Kingston Parish Council has No Objection to the application subject to consideration being given to the following:

APPLICATION NO: K/31/17/HH

Site Address: 53 Golden Avenue Kingston BN16 1QX

Description of Works: Single storey front extension. Two storey rear extension including balcony. Replacement of existing roof tiles & alterations to external appearance.

First Floor Plan

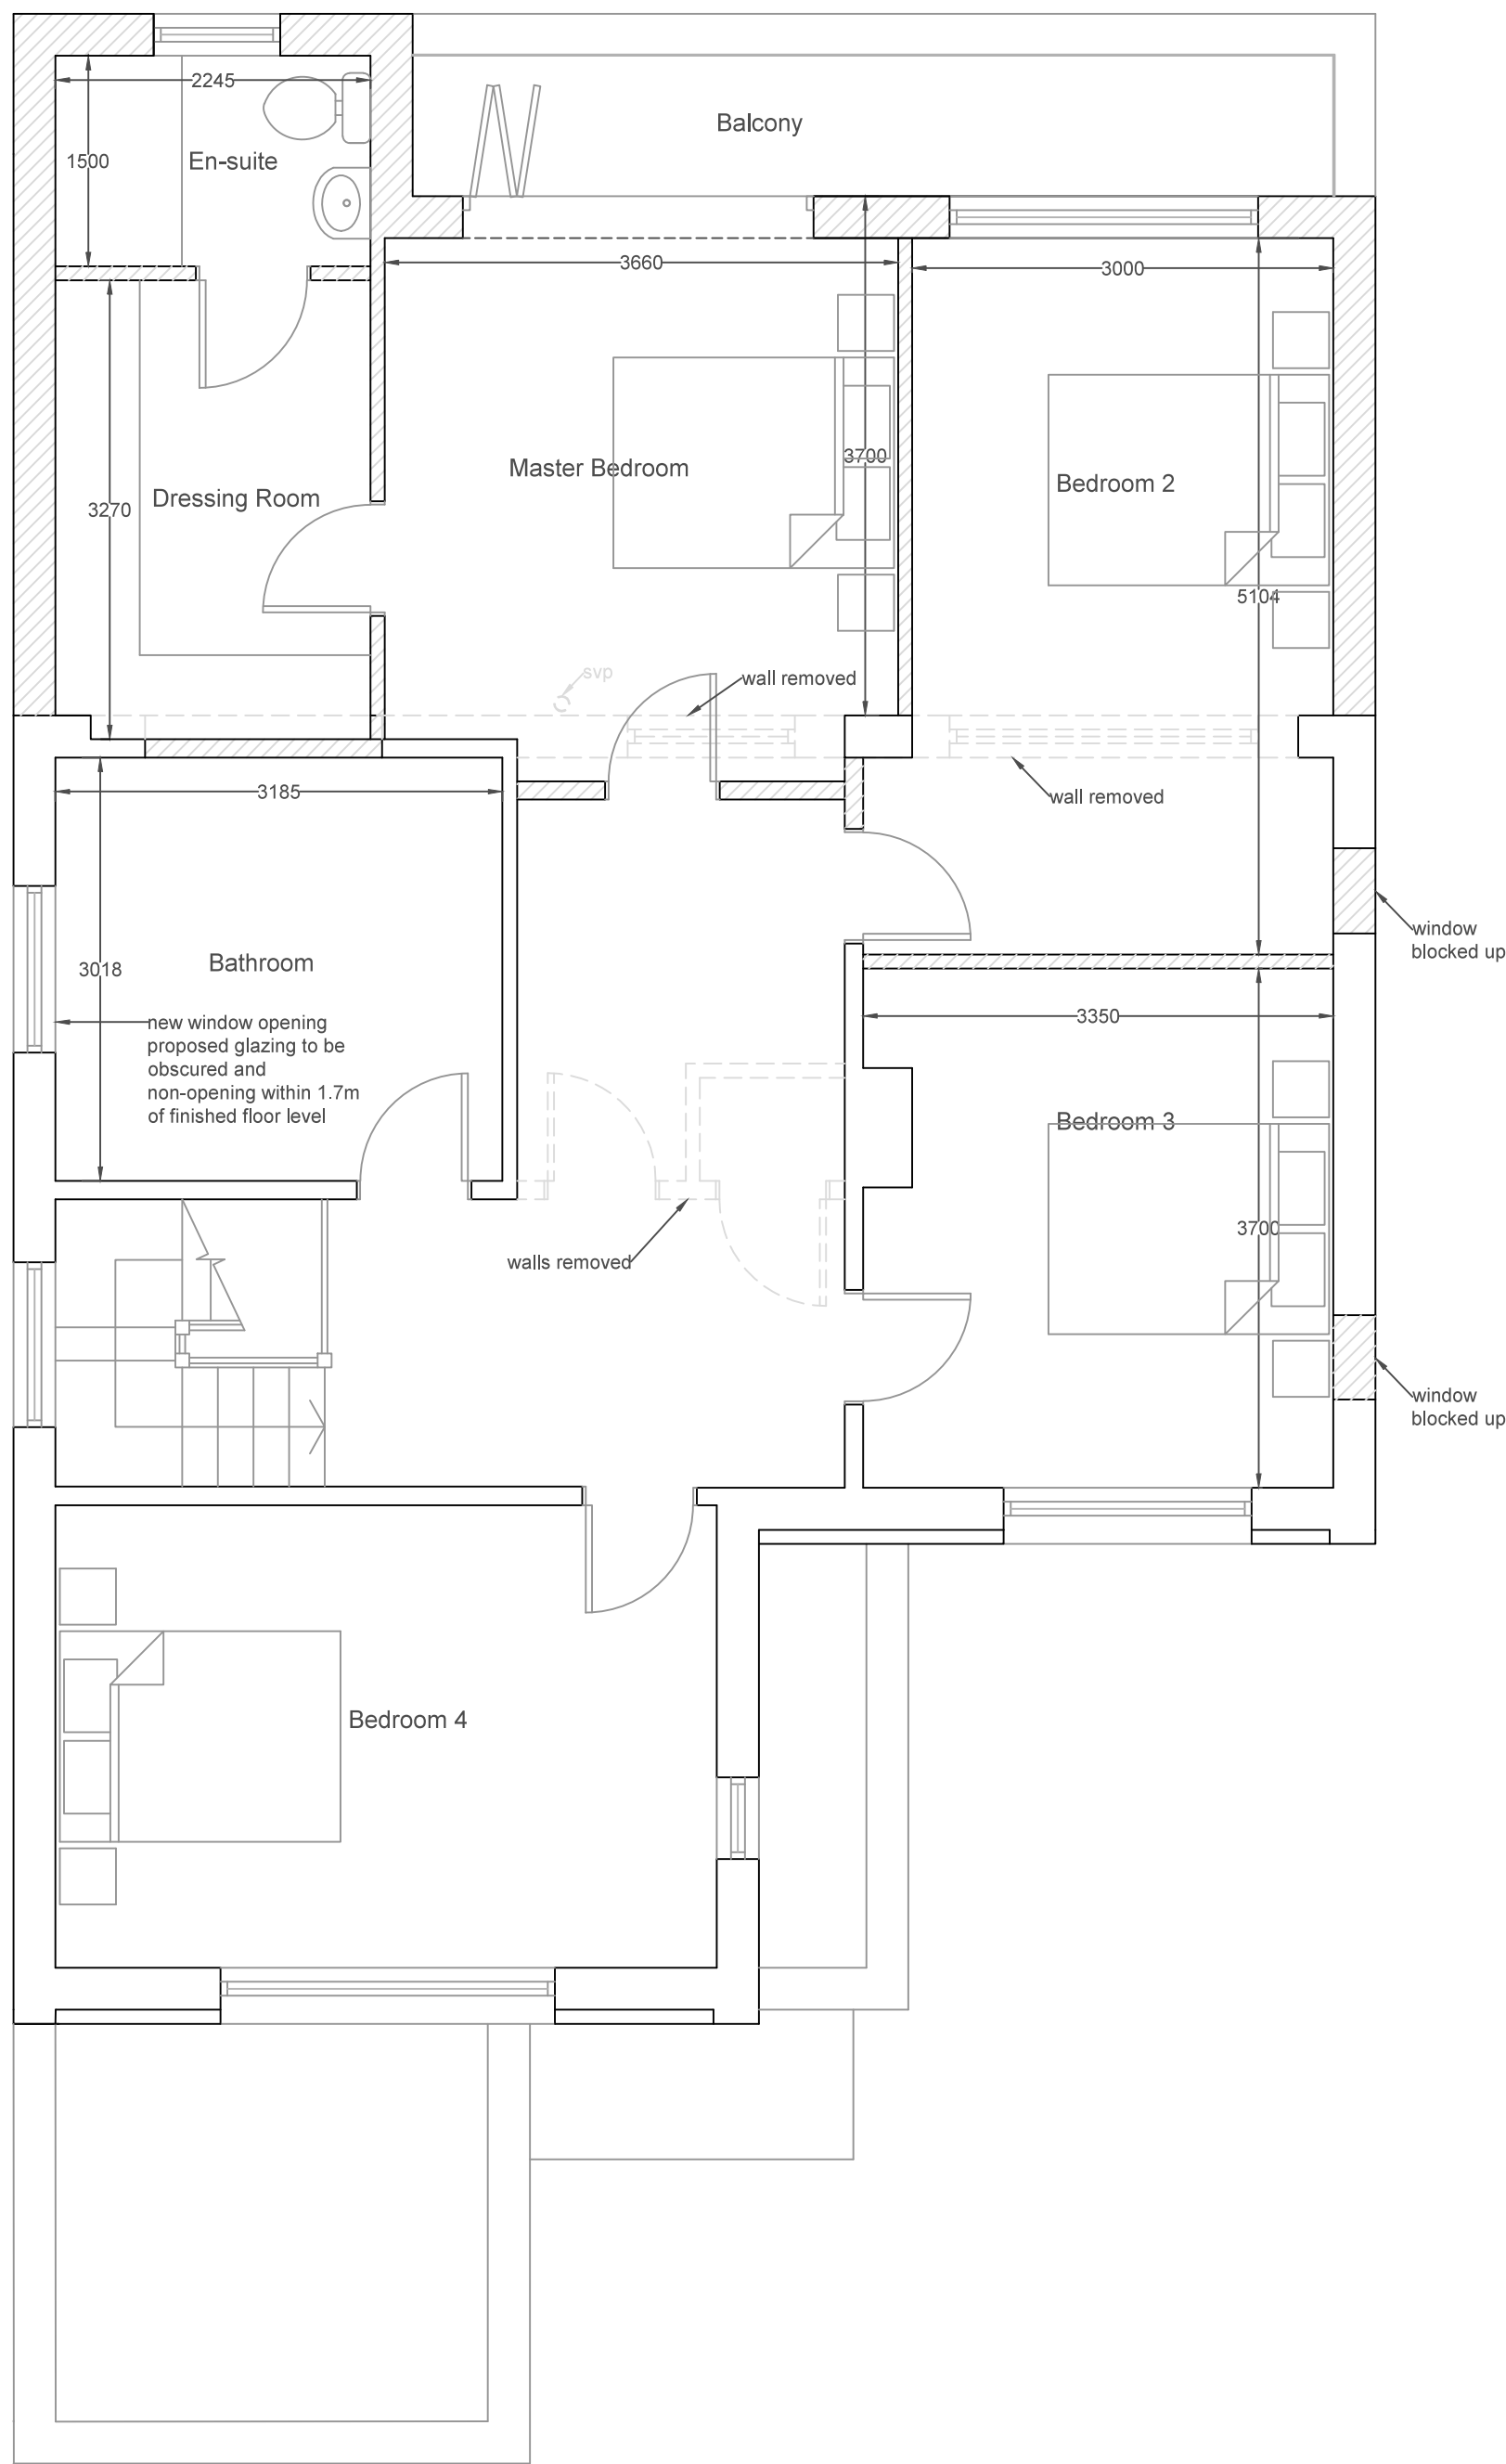
- that, to protect the privacy of neighbours, where appropriate on the first floor there are conditions that obscure glass and fixed

openings are used on overlooking windows and privacy screens fitted to the balcony.
